Recommendation Report for Planning Permission for Works or Extension to a Dwelling

REF NO: M/43/26/HH

LOCATION: 36 Southdean Drive
Middleton-on-sea
PO22 7SX

PROPOSAL: Proposed first floor extension, including internal and external alterations.

ADDRESS: 36 Southdean Dr, P022 7SX	SCALE: 1:100 @ A3	DATE: 30/06/26
DRAWING: Proposed Plans	DRAWING NUMBER:	03
A: 14 Cambridge Court, Cambridge Road, Puckeridge, SG11 1SB	T: 07944211585	E: info@wall2wallplanning.co.uk

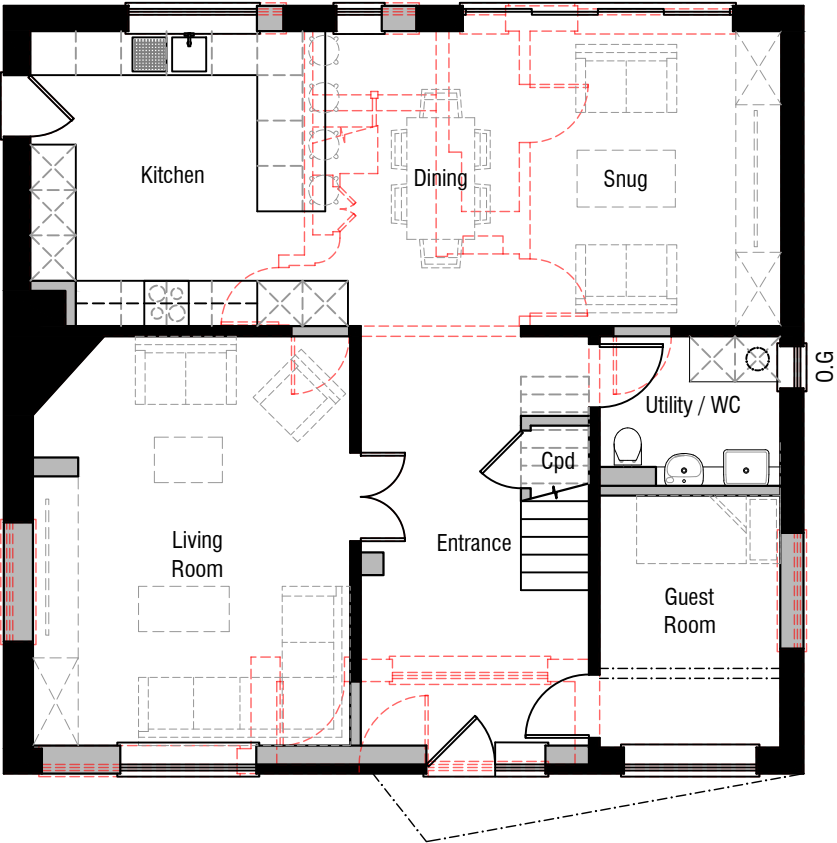
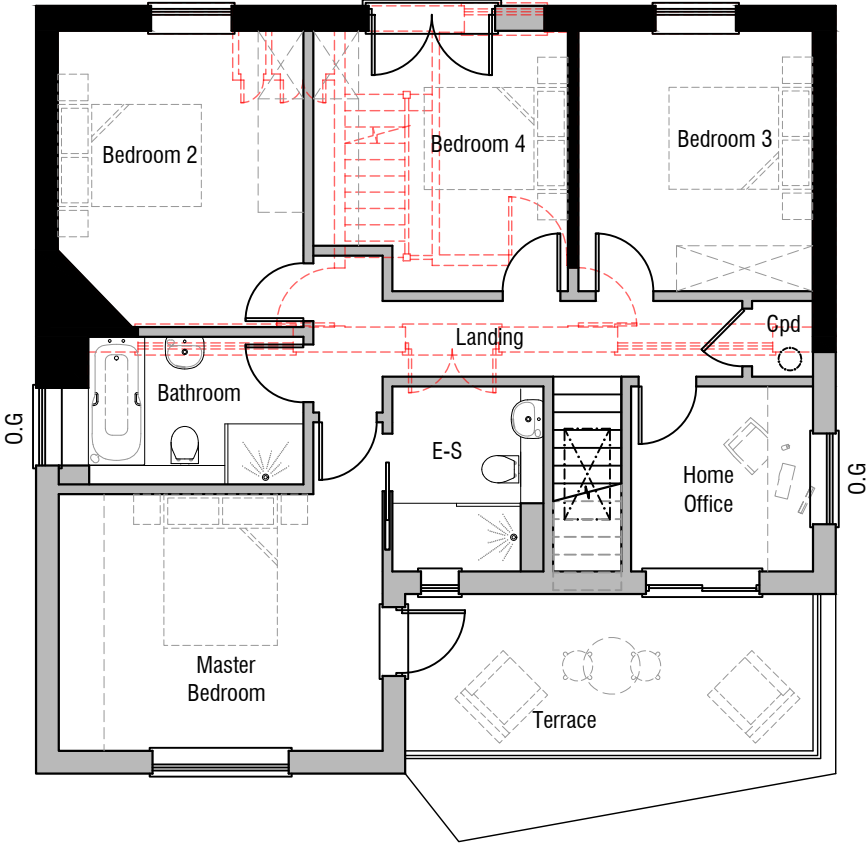
The proposed first-floor front extension would be set 3.6m from the southern side boundary, 7.7m from the eastern front boundary and 1.4m from the northern side boundary. Although the northern separation would not comply with the 2m guidance in Part M of the ADG, the extension would sit above the existing footprint and would not project beyond neighbouring dwellings. The retained spacing would not result in harmful overbearing or overshadowing impacts.

The proposed first-floor extension would be built over the existing dwelling's footprint and would not increase ground impermeability in this area. As such, the proposed development would not increase the risk of flooding elsewhere and is acceptable in accordance with Arun Local Plan policies W DM1 and W DM3, policy MOS3 of the MoSNP, and the NPPF.

ADDRESS: 36 Southdean Dr, PO22 7SX	SCALE: 1:100 @ A3	DATE: 30/06/26
DRAWING: Proposed Elevations	DRAWING NUMBER:	04
A: 14 Cambridge Court, Cambridge Road, Puckeridge, SG11 1SB		
T: 07944211585		
E: info@wall2wallplanning.co.uk

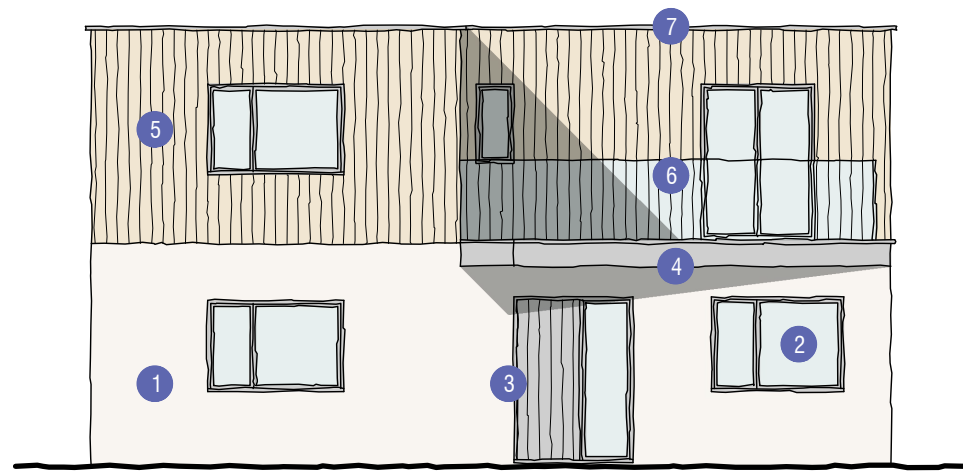
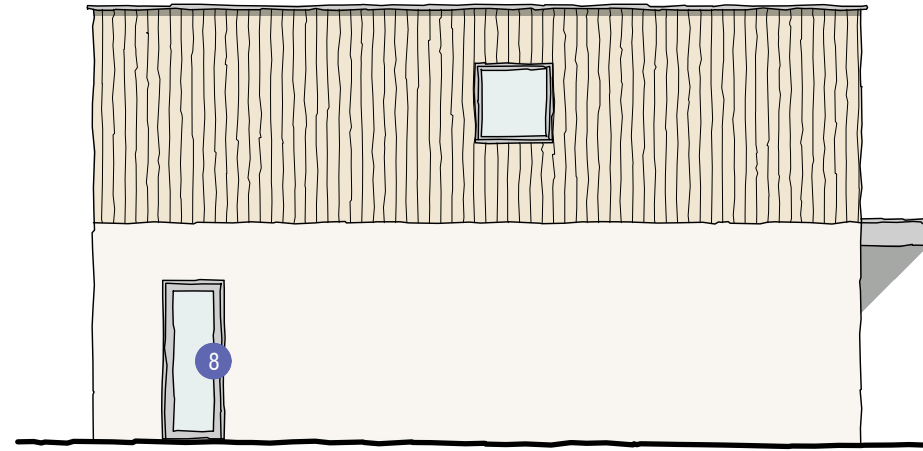
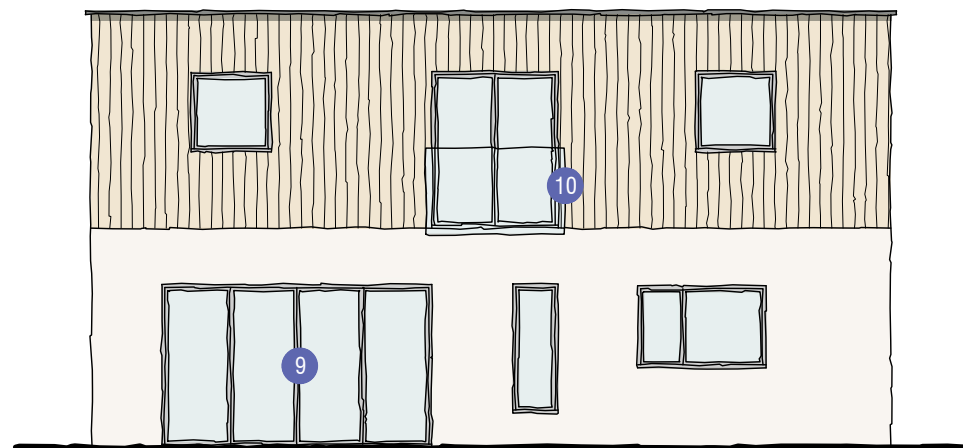
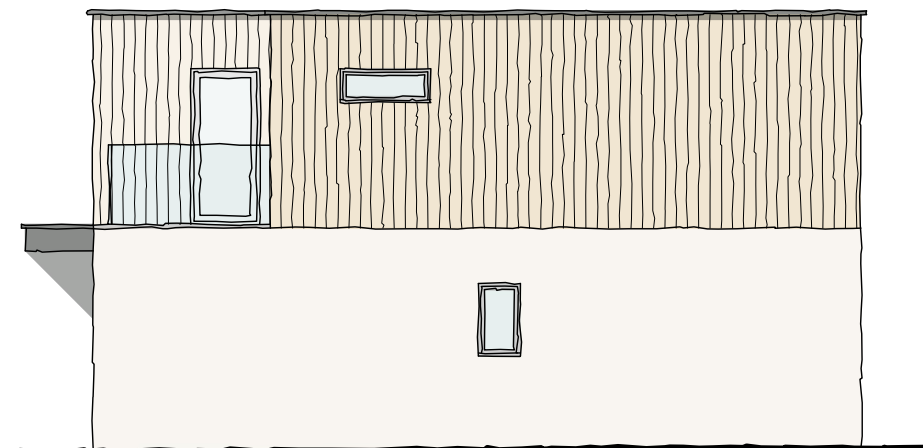
The proposed first-floor front extension would not increase the footprint of the host dwelling. It would increase the dwelling's first-floor depth by 5m to 10.15m to the south-eastern aspect of the front elevation and by 2.8m to 7.8m on the north-western elevation. It would extend across the full width of the dwelling, over the existing ground floor projection, and therefore would not accord with Part M of the Arun Design Guide, which advises that front extensions should not exceed 1.5m in depth or span the full width of the building. However, the extension would sit above the existing footprint, would not project forward of the existing building line, and would be seen within a street scene of varied and staggered front elevations. On this basis, it would not appear incongruous or harmful to visual amenity.

The proposed first floor extension would introduce natural vertical timber cladding with roof materials to match the existing. Although the materials would introduce a more modern appearance, the street scene has no uniform design character. The proposed materials would not appear at odds within the wider context, in accordance with Arun Local Plan policies D DM1 and D DM4 and policy MOS6 of the MoSNP.

The proposed fenestration would include new and altered windows and doors on all elevations. Frames would be aluminium in anthracite grey RAL 7016, with a grey composite vertically boarded entrance door to match. The design and finish would be consistent with the proposed contemporary appearance of the extension. The proposed fenestration changes are small in scale and would not result in harm to the host dwelling or wider street scene.

The proposed terrace balcony on the front south-eastern elevation would be 1.05m high, 5.5m wide and 2.1m deep. It be finished with glazing screening and would be sympathetic to the design of the dwelling and would not result in harm to visual amenity.

Part M of the ADG states that canopies can also be added to a house to provide a threshold space between the interior and exterior and add emphasis to the entrance. The proposed splayed front canopy would be approximately 2.9m high, and at its widest point 1.1m, wrapping around from the south-eastern front elevation to the north-eastern side elevation with a depth of 0.9m. It would be finished with aluminium and have coping in anthracite grey RAL 7016. The proposed canopy would integrate with the design of the first-floor front extension and would not result in harm to visual amenity.

The proposal would introduce first-floor windows on the south western and north eastern elevations. Both would be obscure glazed, which would prevent unacceptable overlooking. Notwithstanding this, given the siting of the windows, it is not reasonable to attach a condition to require the windows to remain obscurely glazed in perpetuity. The neighbouring property to the north east has a first-floor terrace above its garage, while other nearby properties also include front terraces and glazed balustrades. In this context, the proposal would not result in unacceptable overlooking or loss of privacy to neighbouring properties.
